**RE: Lot 12 Block 2 Unit 19 Volcano Cliffs SAD 228
6520 Camino Del Oeste NW
Grading and Drainage Plan
Engineers Stamp Date 4/5/17 (D10D003G12)**

Based upon the information provided in your submittal received 4/05/17, this plan cannot be approved for Grading Permit until the following comments are addressed.

ENGINEER'S SEAL  4/11/17 DAVID SOULE P.E. #14522	6520 CAMINO DEL OESTE	DRAWN BY WCWJ
	GRADING AND DRAINAGE PLAN	DATE 4-10-17
	 Rio Grande Engineering 1606 CENTRAL AVENUE SE SUITE 201 ALBUQUERQUE, NM 87106 (505) 872-0999	21727-LAYOUT-4--04-17
		SHEET # JOB # 21727

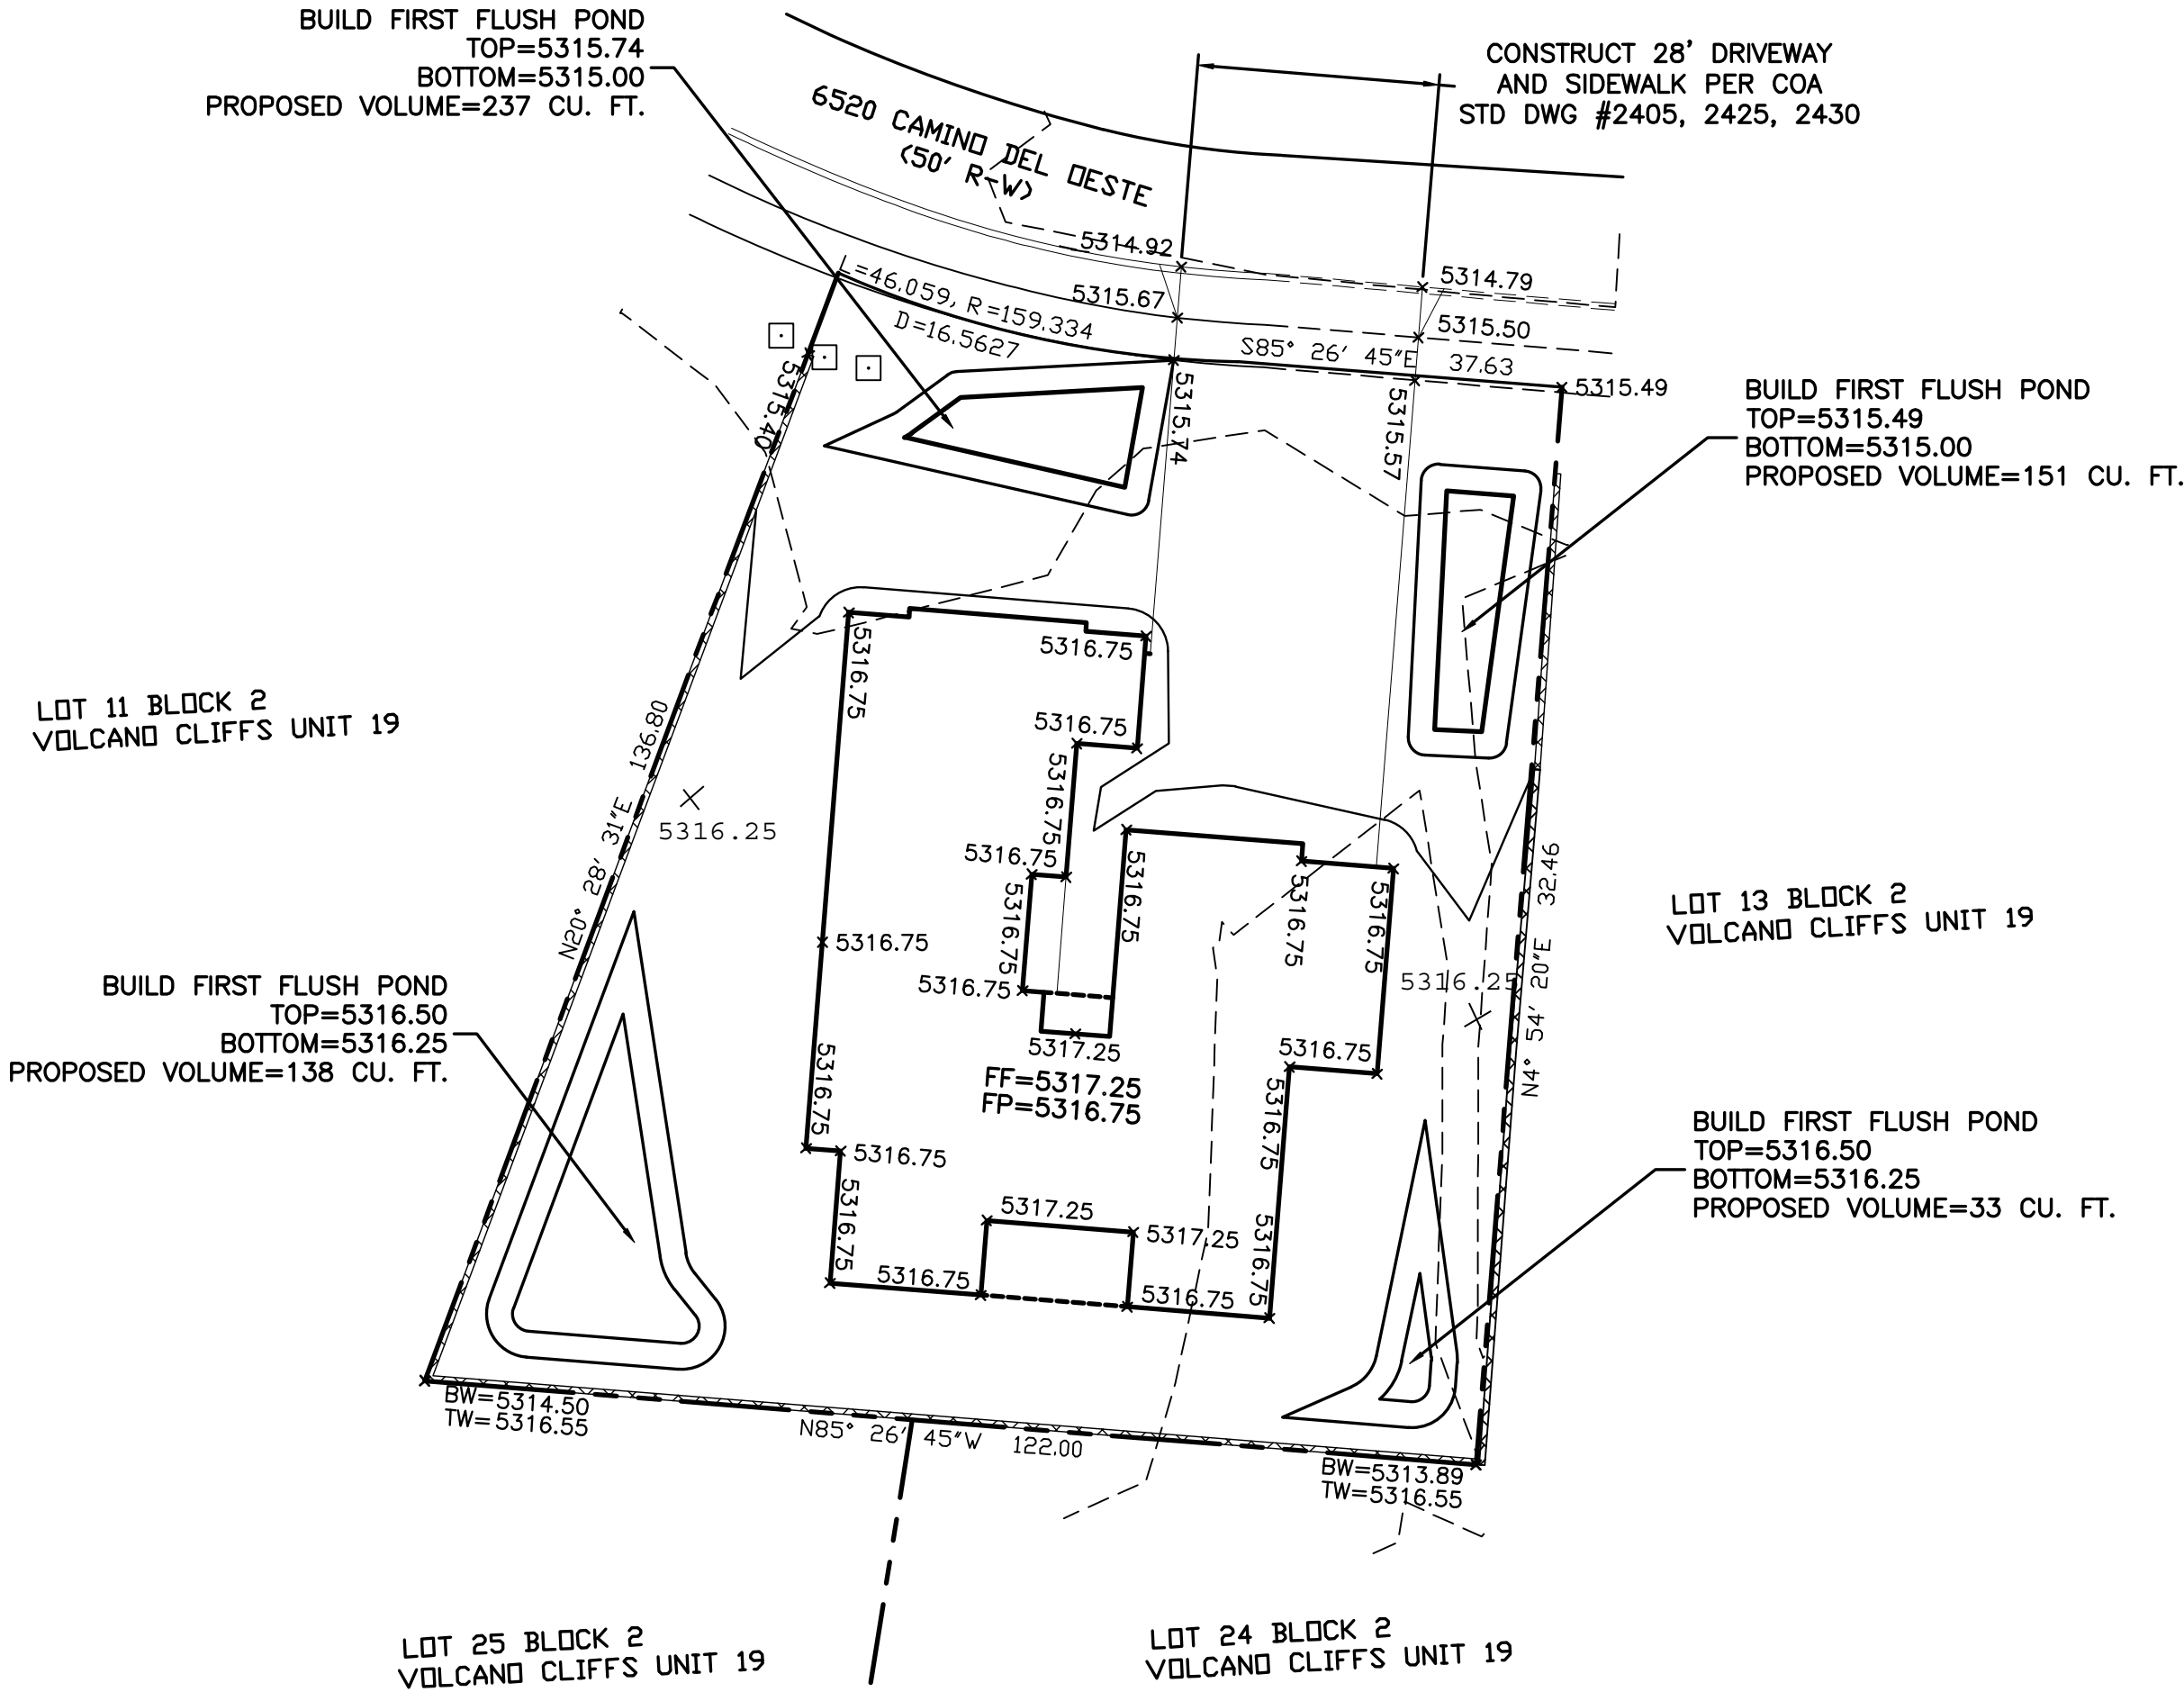
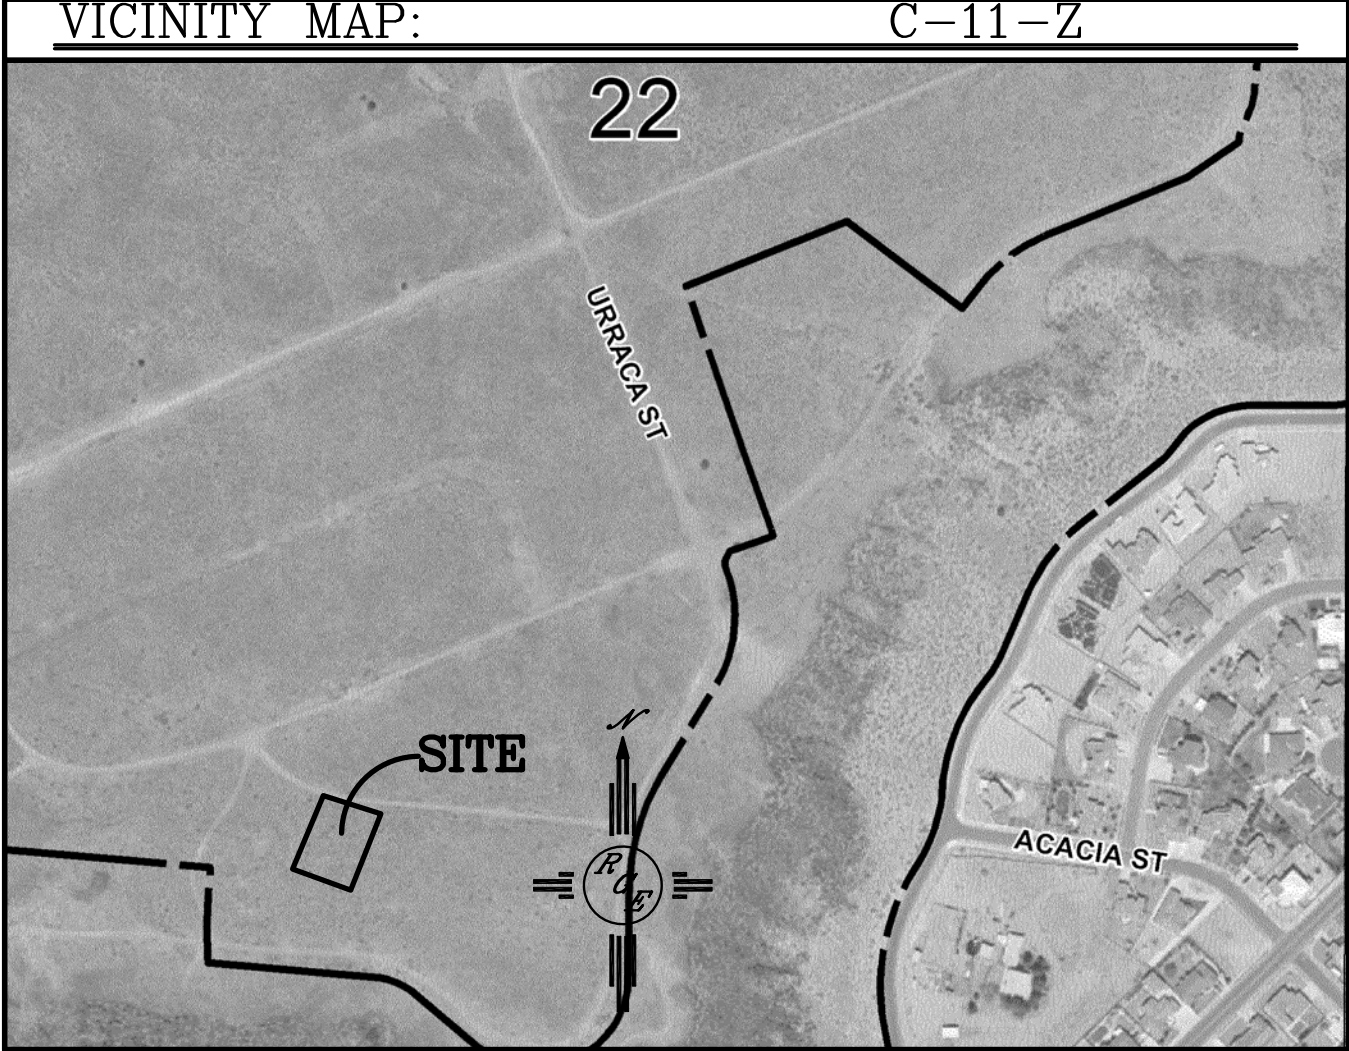
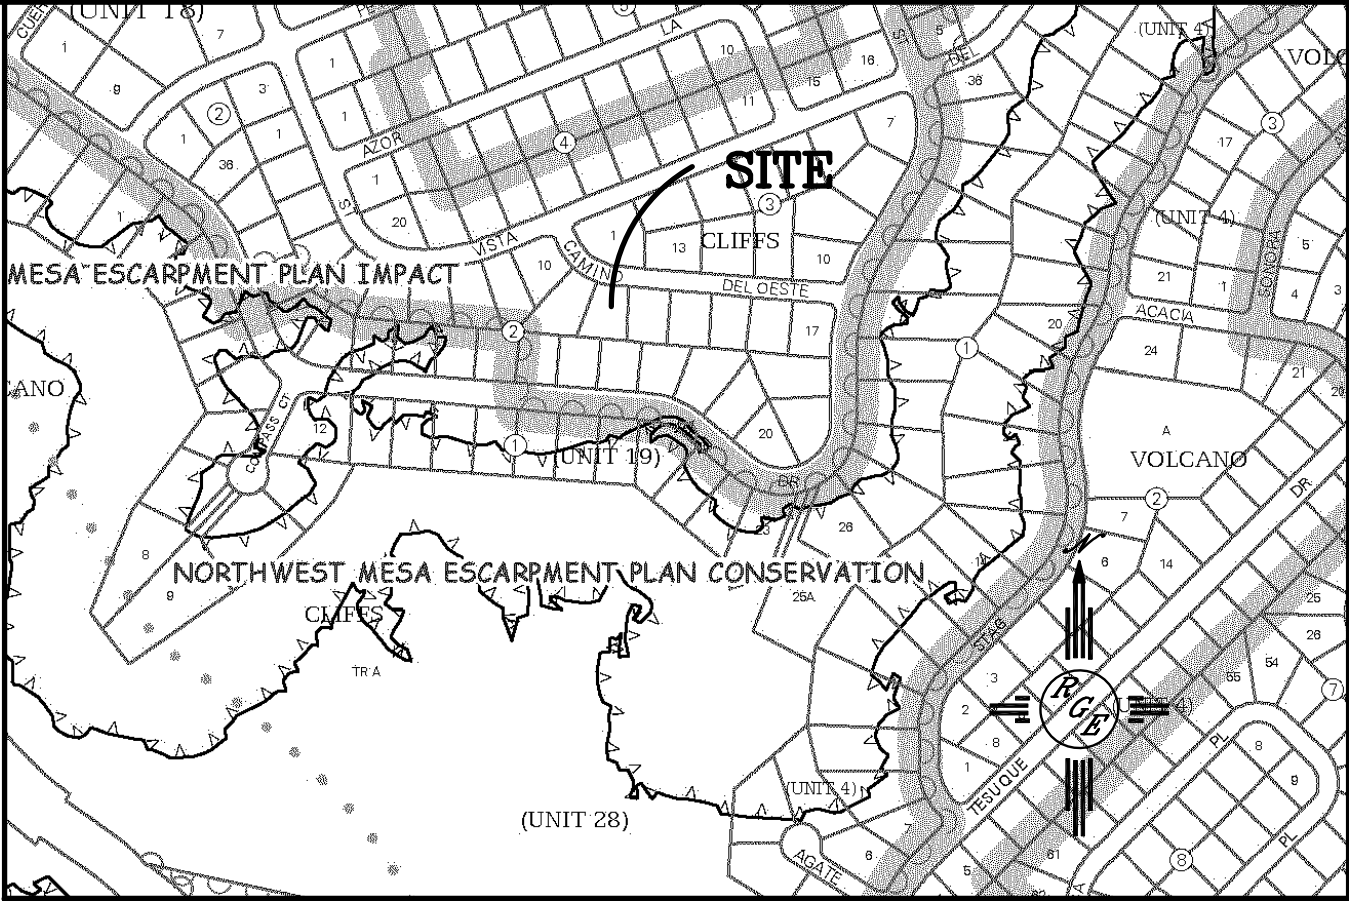
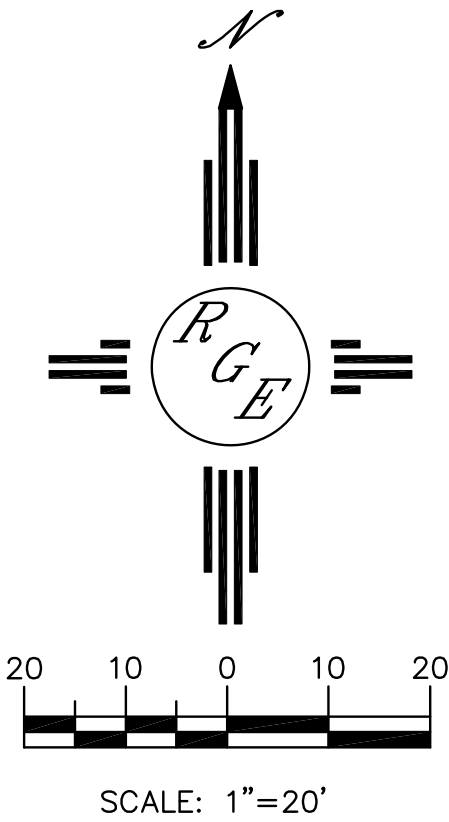
- All drainage to exit front yard via first flush pond.
- Removes openings in block wall.
- Remove statement for cross lot drainage.
